### **DEPARTMENT OF PUBLIC WORKS**

**RE:** SE-20-00003 - Brown and Jackson, Inc.

Please see attached Public Works comments regarding Brown & Jackson, Inc. SEPA application SE-20-00003.

SHEET NO.
C1.1
201834

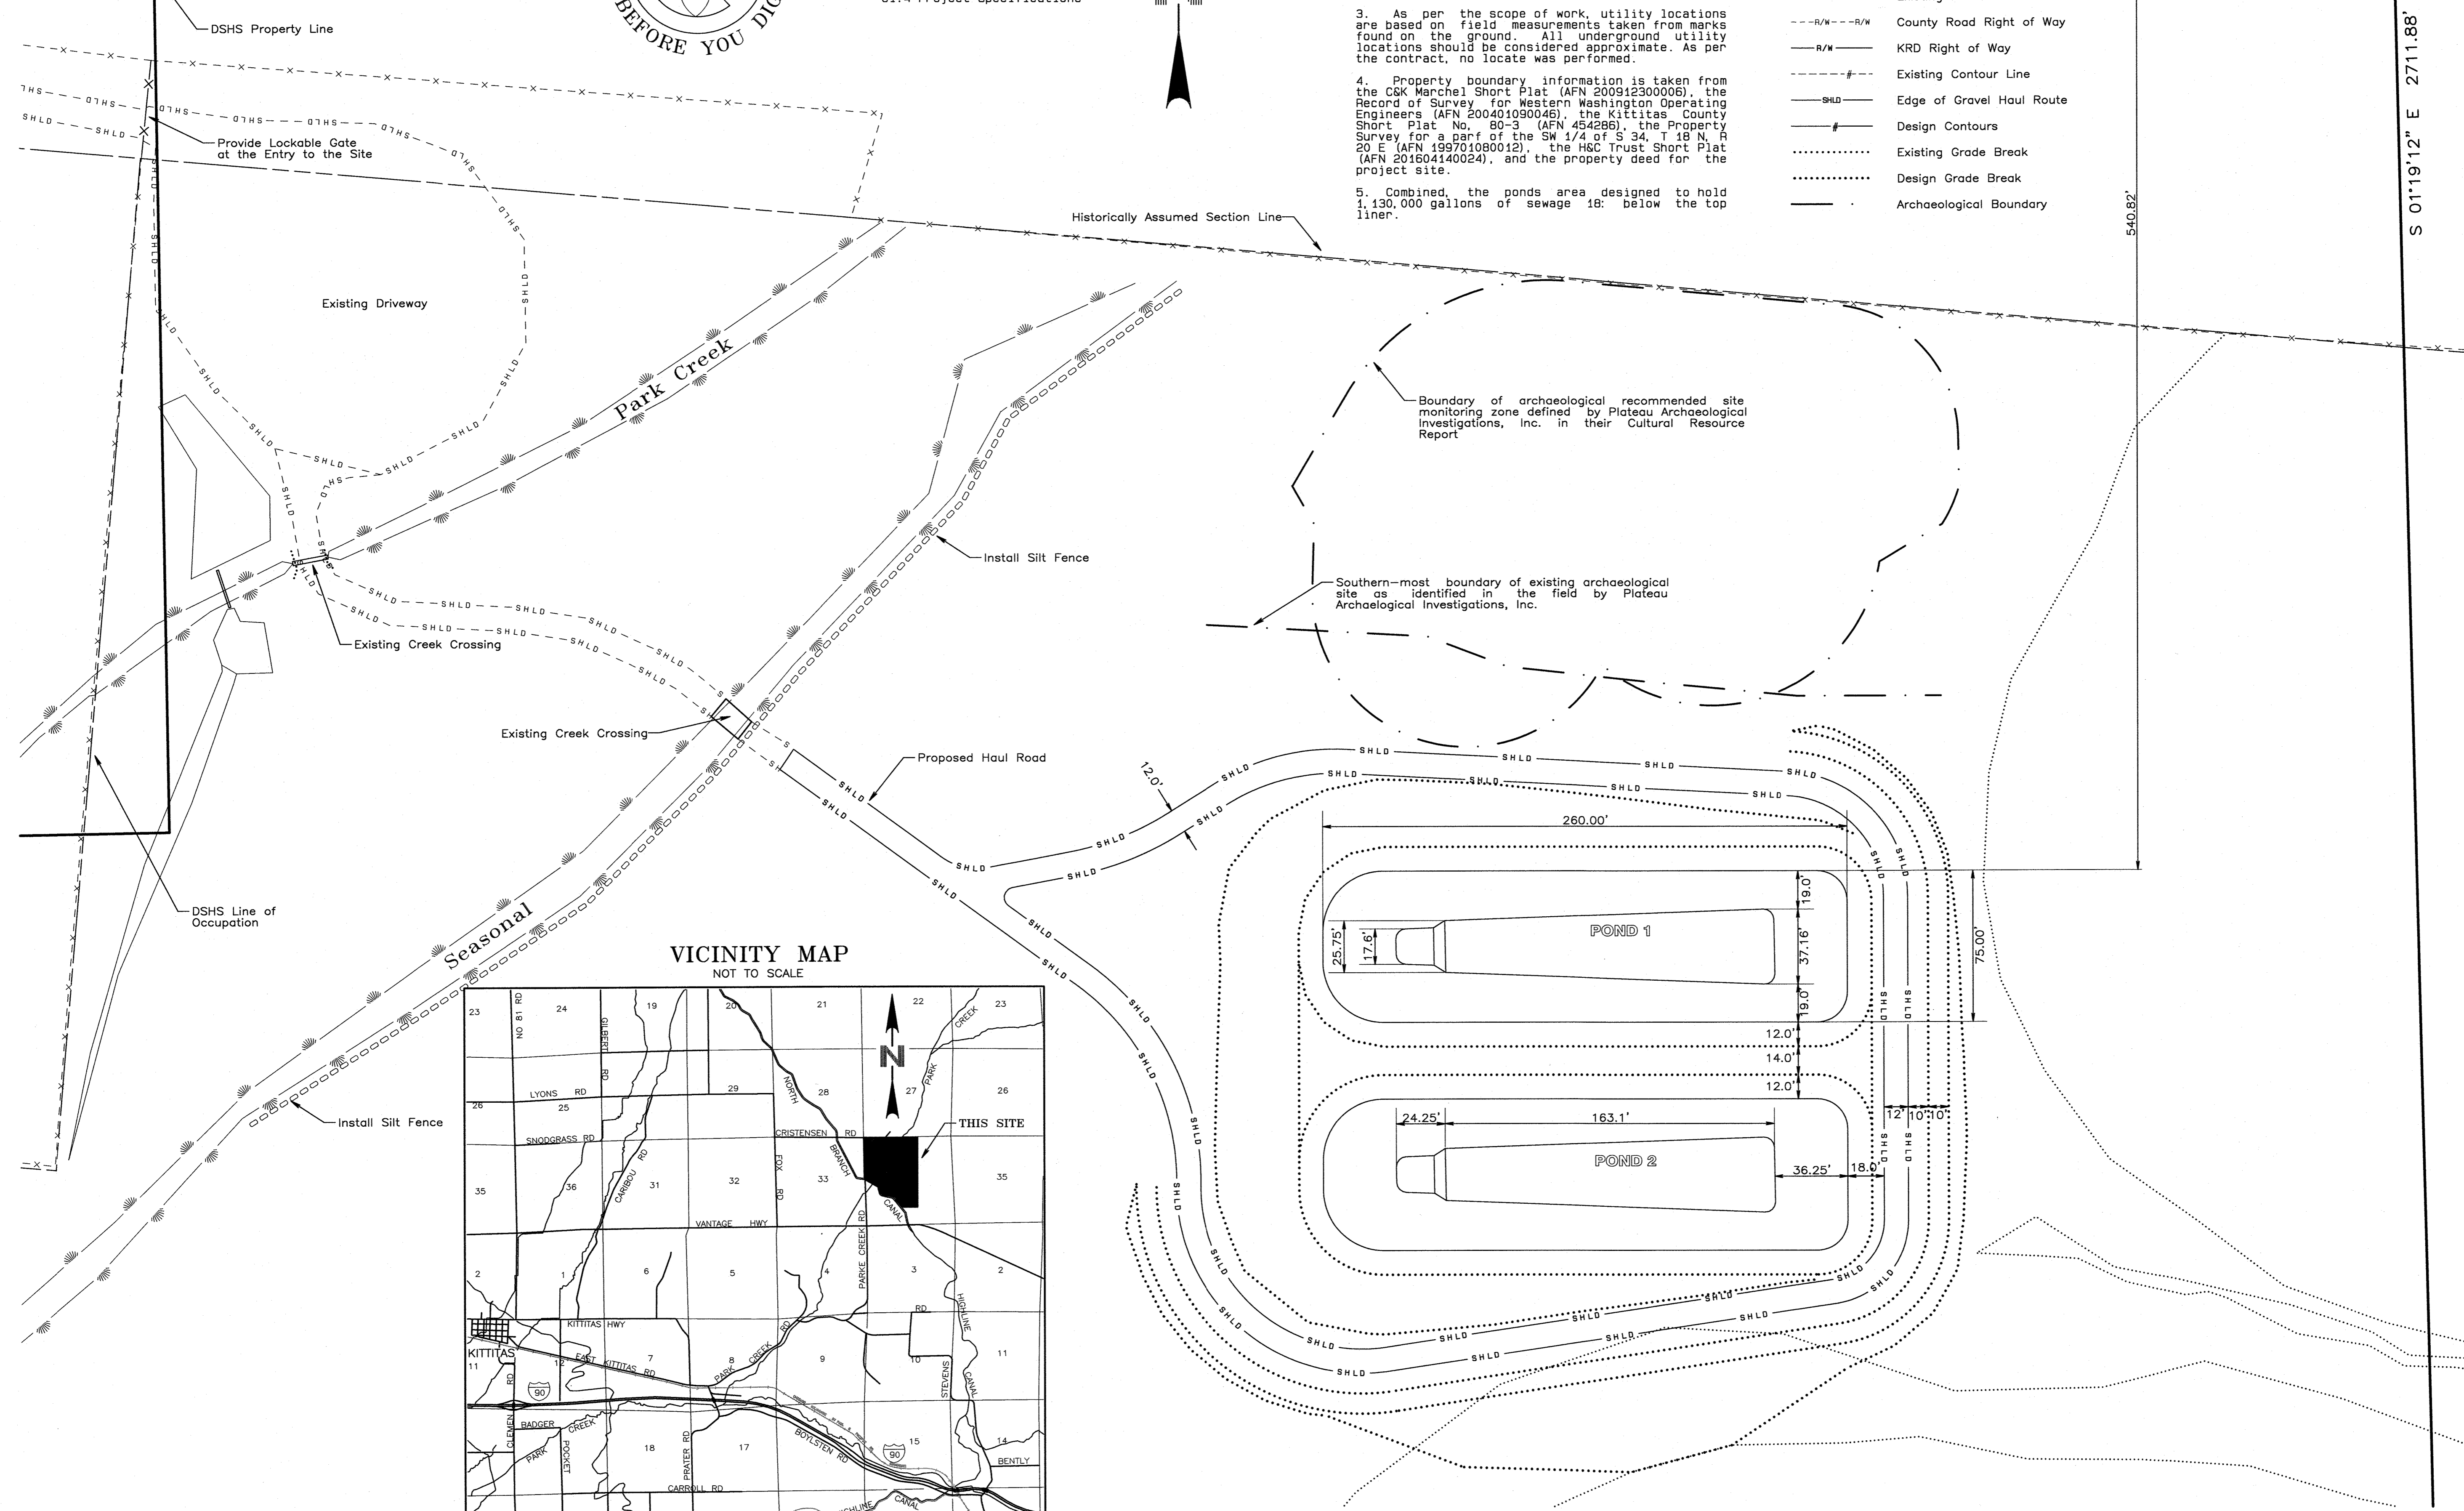
1. Access. A commercial paved access pursuant to Kittitas County Code Chapter 12 shall be installed prior to any commercial use.
2. Private Bridge. A private bridge design permit shall be completed for Public Works review. All necessary permit requirements shall be completed prior to any commercial use. The bridge shall be posted for the required 75,000-pound load limit prior to any commercial use.

SHEET NO. C1.2
201834

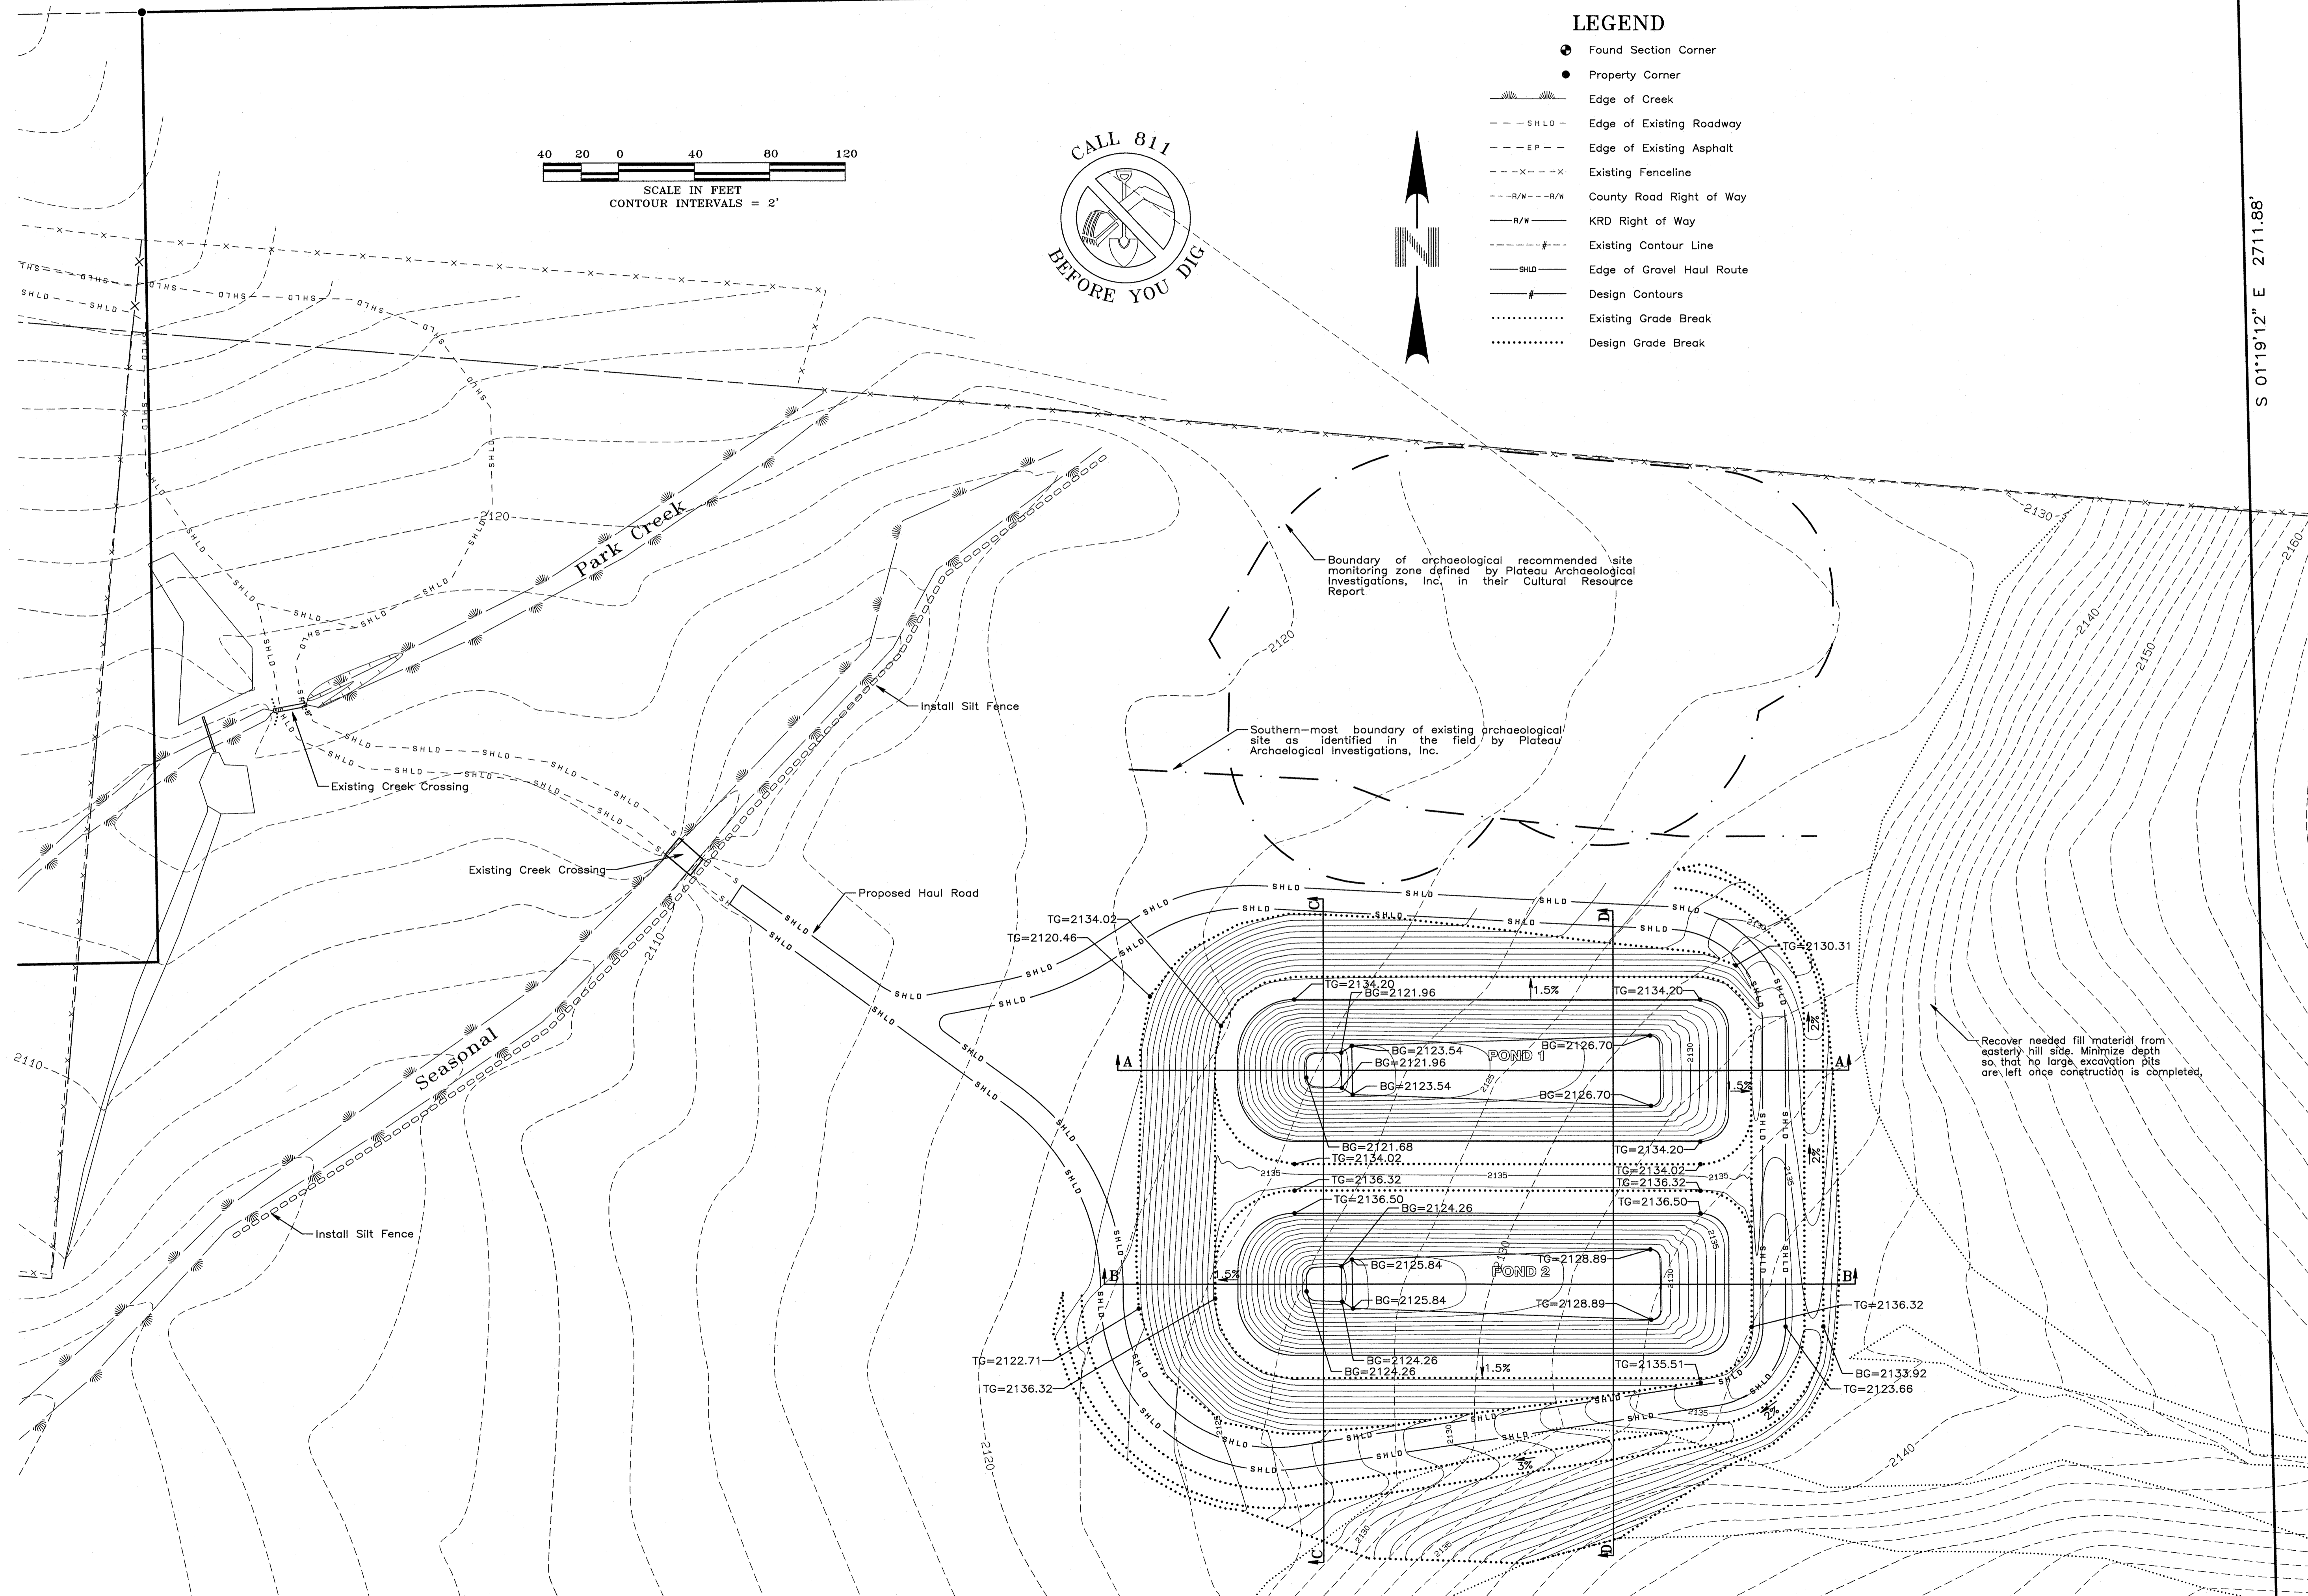
3. Stormwater. An engineered design stormwater plan shall be completed for the proposed lagoon(s) and any additional impervious area associated with the proposal (SEPA Checklist). The plan shall follow design requirements as stipulated in the current Washington State Department of Ecology stormwater design manual for Eastern Washington.
